Planning Application Ref: P/48/21/T

Location: 20 Spinnaker View, Pagham, PO21 3FL

Description of works: Crown reduction of 2no. poplar trees to 26m in height and 5m in width

PLANNING APPLICATION

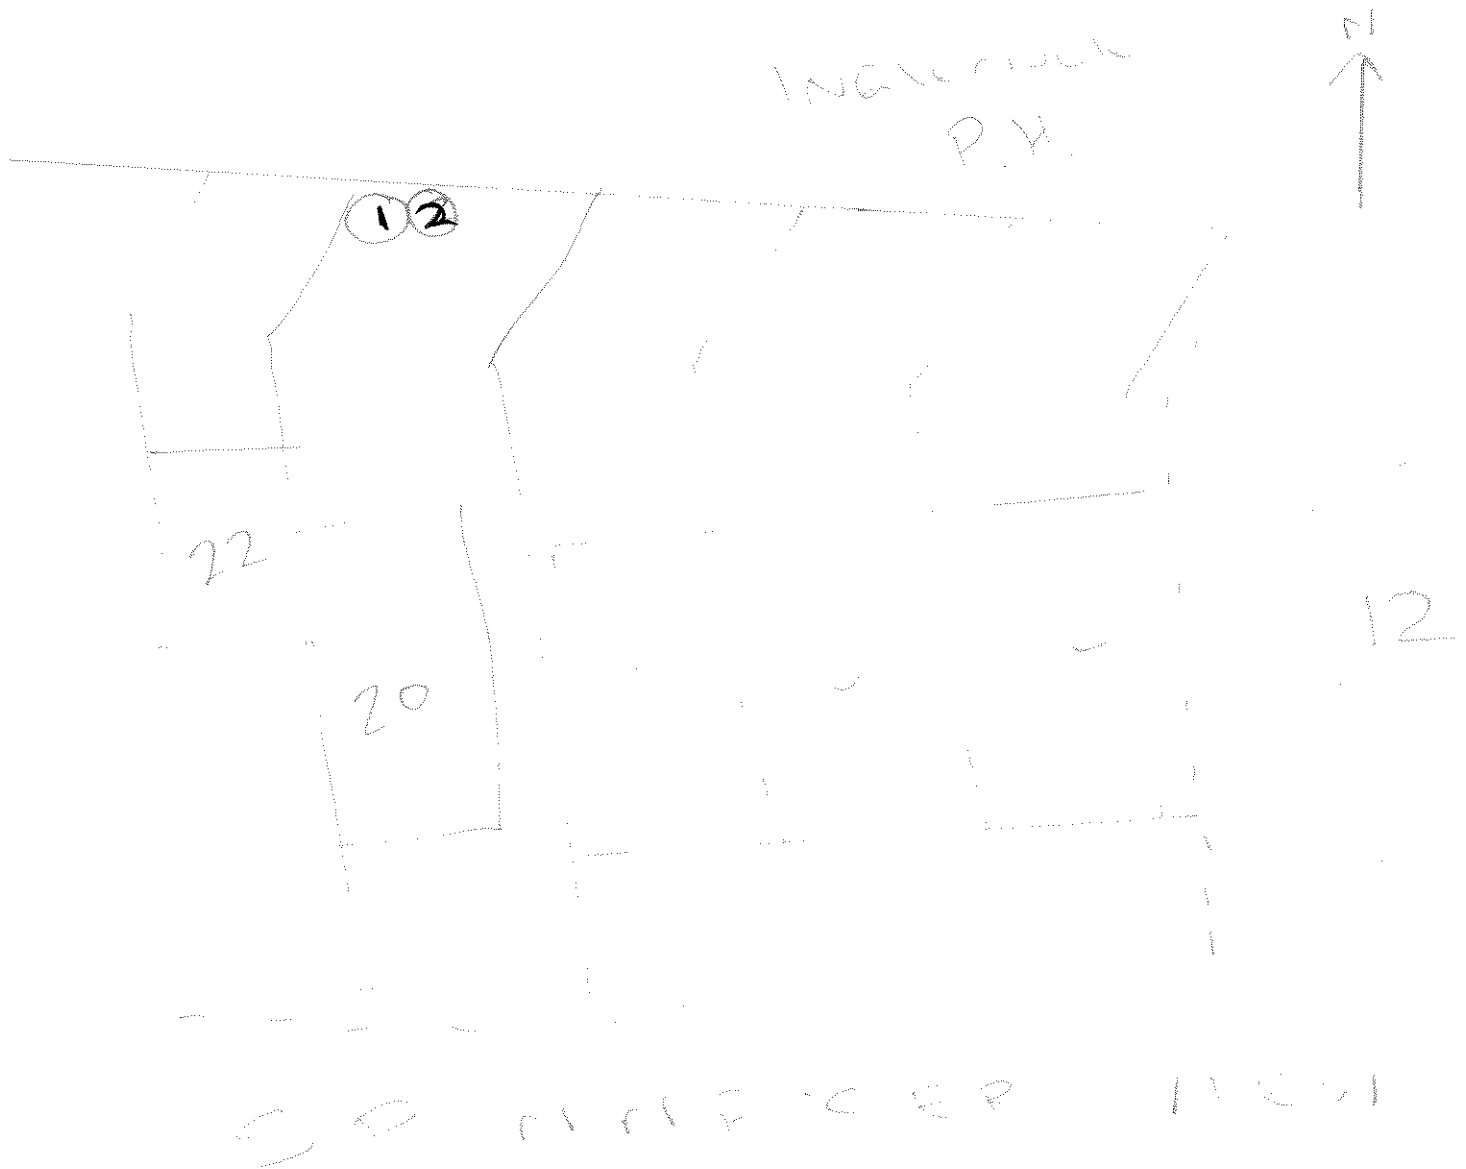
- Outwardly and from distance (roadside) this tree appears to be in a fine physiological state (and assumed to be so in the absence of any information/evidence provided to the contrary). Described as two individual trees, which I could not substantiate from my limited perspective, although did clearly observe a tight cluster of five dominant stems that support a shared high-crown profile which is both unmodified and visually impressive.

- Both the original Arboricultural Survey submitted with planning ref. P/125/14/PL and Tree Preservation Order documentation; describe one poplar with multiple stems at this location. In any event, we can be confident the applicant proposes work to mature poplar in the rear garden of their property.

- While my estimation of tree height differs significantly from the applicant's, I attach more value to discussing the principle of 'crown reduction pruning' at this time.

- The tree work operation proposed in the application has not been justified on arboricultural grounds.
- The tree is a significant feature in the local landscape and appears to be in adequately sound and healthy condition. The tree surgery proposed in the application would result in excessive reduction of the tree's landscape impact and undue detriment to the visual amenities of the locality.

- I recommend **REFUSAL** for this application.
